Application Ref:	3/2025/0922				Ribble Valley Borough Council www.ribblevalley.gov.uk
Date Inspected:	22/5/26	Site Notice:	1/5/26		
Officer:	BT				
DELEGATED ITEM FILE REPORT:				REFUSAL

Development Description:	Change of use from agricultural building to single residential self-build dwelling and associated residential curtilage together with hardstanding/parking.
Site Address/Location:	Land at Pendleton Road, Wiswell, BB7 9BZ.

PROPOSED GROUND FLOOR PLAN. SCALE 1:50

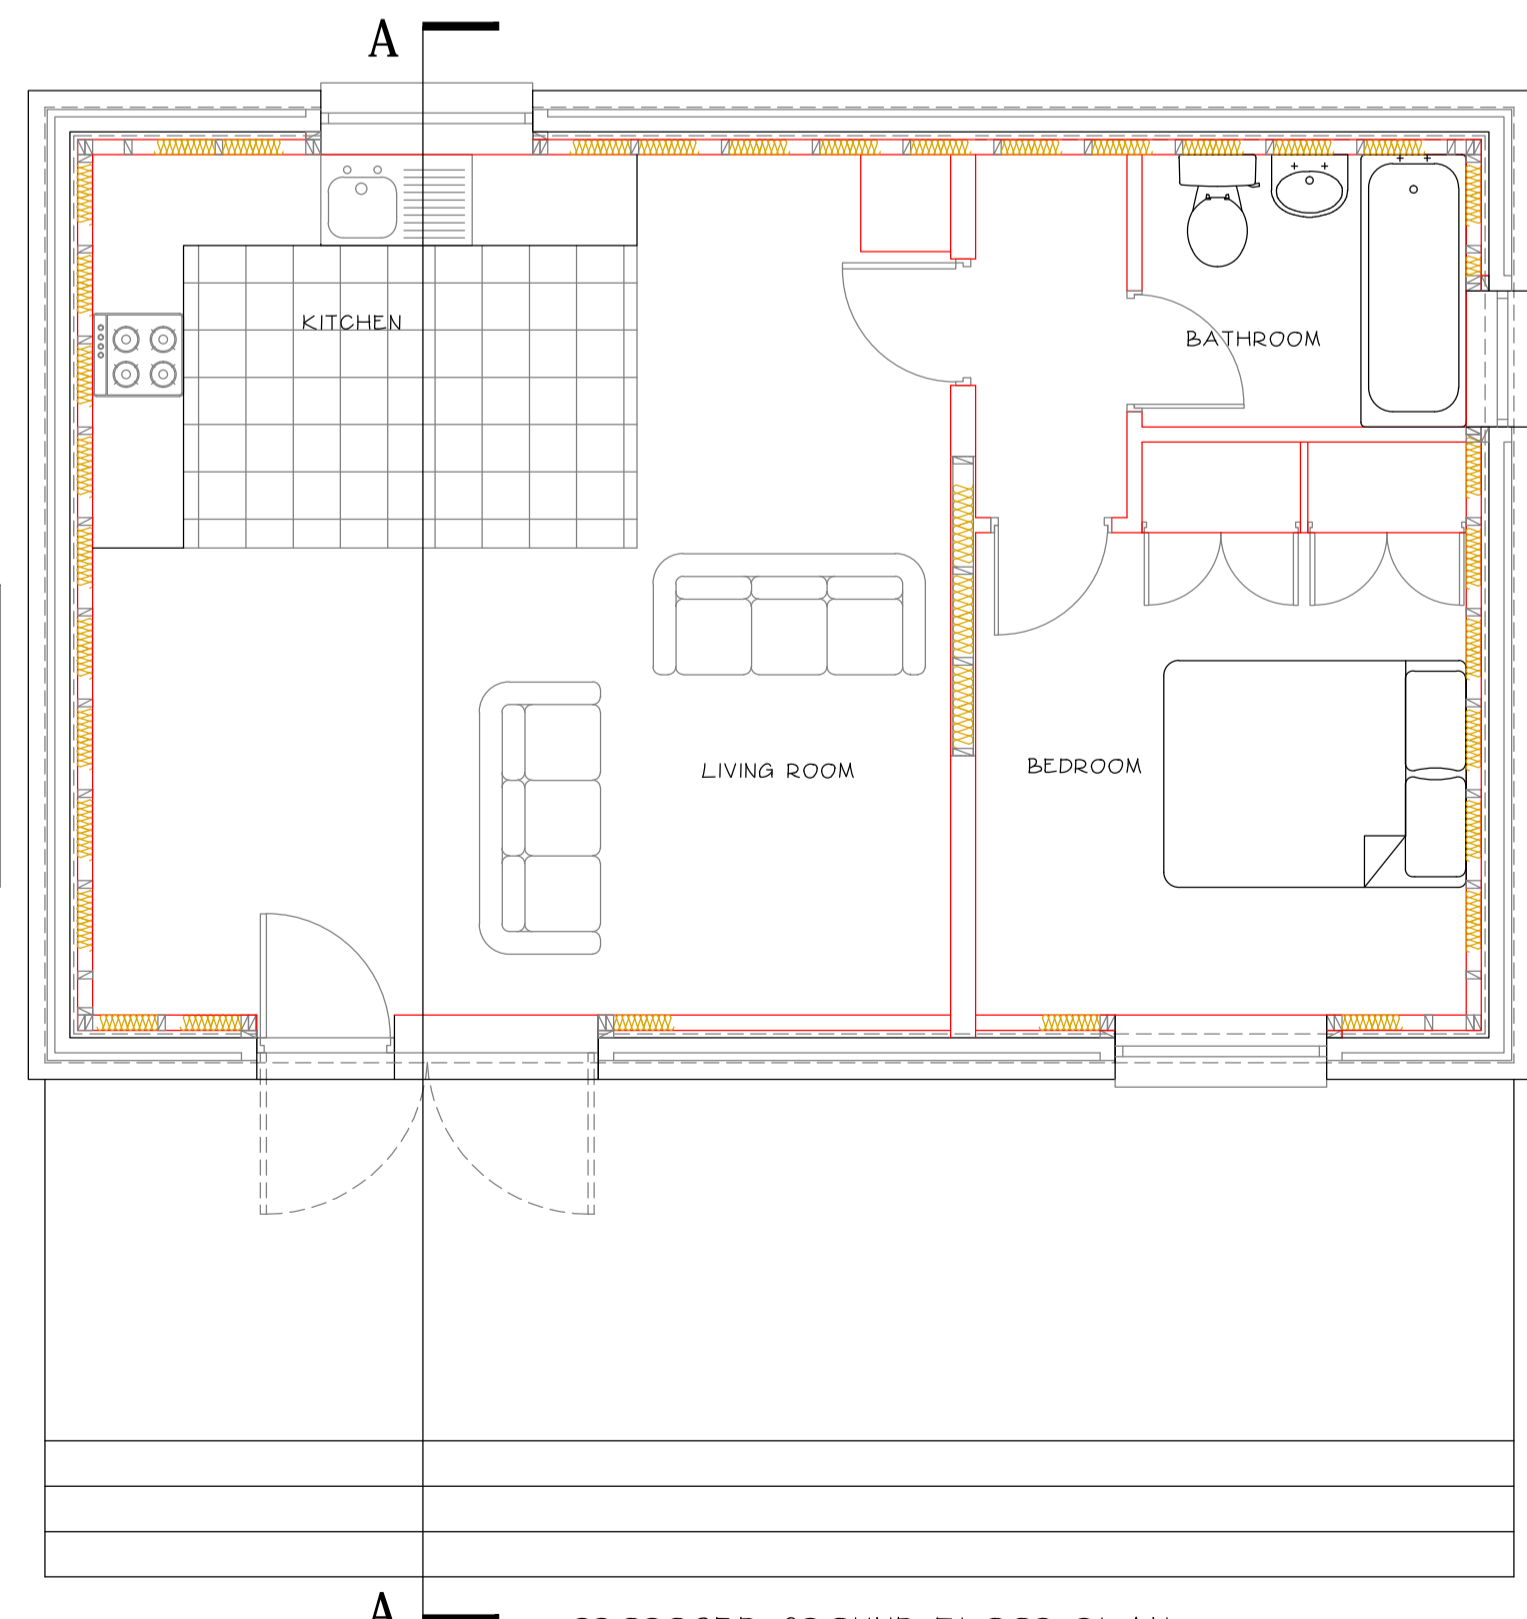
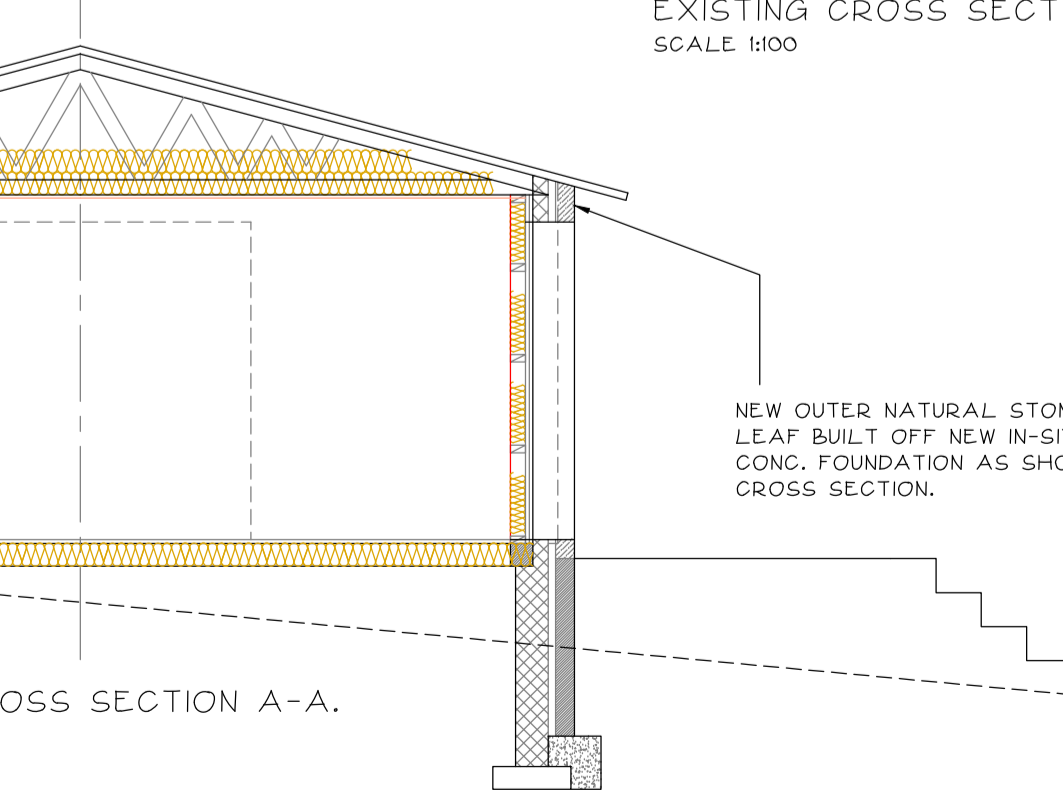
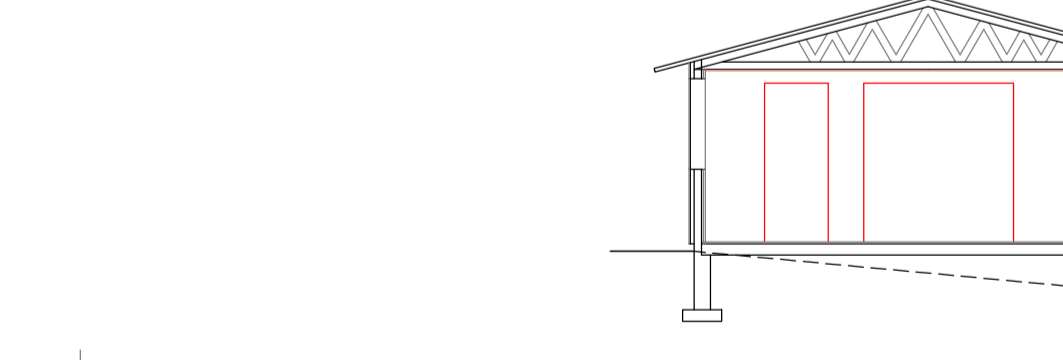
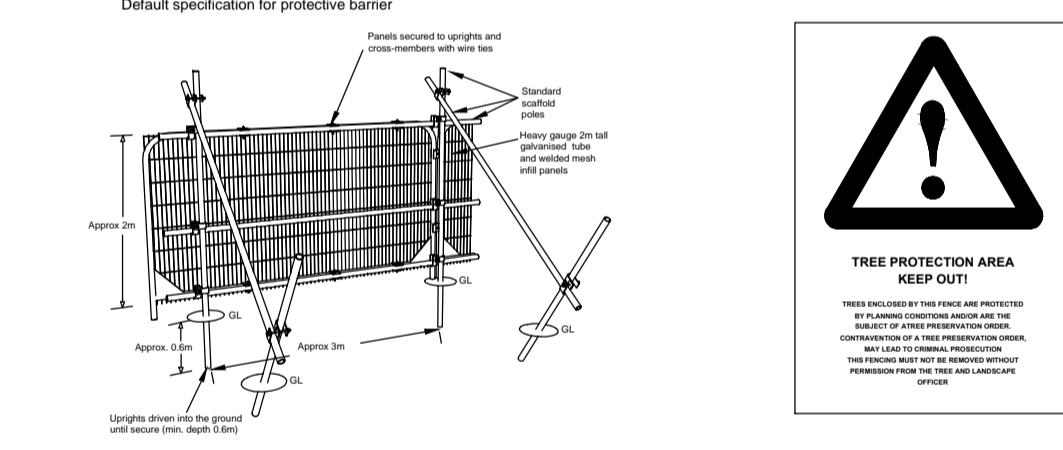
In addition, criteria point 6 (1) of Policy DMH4 requires buildings being converted to residential use to be structurally sound and capable of conversion without the need for extensive building or major alternation which would adversely affect the character or appearance of the building. In this case, the application's structural survey states that in order to convert the application property into a dwelling there would likely be a requirement to underpin and widen the existing foundations of the building along with a requirement to introduce a ground floor slab, bracing to the existing timber stud walls and additional roof trusses to support the additional loading from the proposed replacement tiled roof and its solar panels. As such, the submitted structural report does not provide a confident indication that the application building would be structurally capable of supporting the proposed development (the submitted structural report states that the work required to convert the property could be more expensive than demolishing the existing property and constructing a new house of equivalent size). In addition, and as conveyed above, the proposal seeks to make significant external alterations to the design of the existing building which in turn would result in the creation of an overtly domestic building which would be at odds with the site's open countryside setting.

added to the front North-western elevation of the building. An incongruous and largely unsympathetic metal housing unit accommodating a solar panel battery and inverter has also been sited adjacent to the building's North-eastern side elevation, with the flat roof symmetry of this structure being noticeably at odds with the gabled roof profile of the application building. In addition, the proposal seeks to make further domestic alterations to the existing building which include the addition of stone cladding to all elevations of the building along with the introduction of a replacement tiled roof with solar panels, with the proposed introduction of a driveway, footpath, hardstanding and terraced steps (in place of the existing timber decking) all adding further urbanisation to the site. Furthermore, the unsympathetic metal housing unit accommodating the solar panel battery and inverter would be retained as part of the development, with the retention of this structure having a further harmful urbanising impact upon the agricultural character of the site.
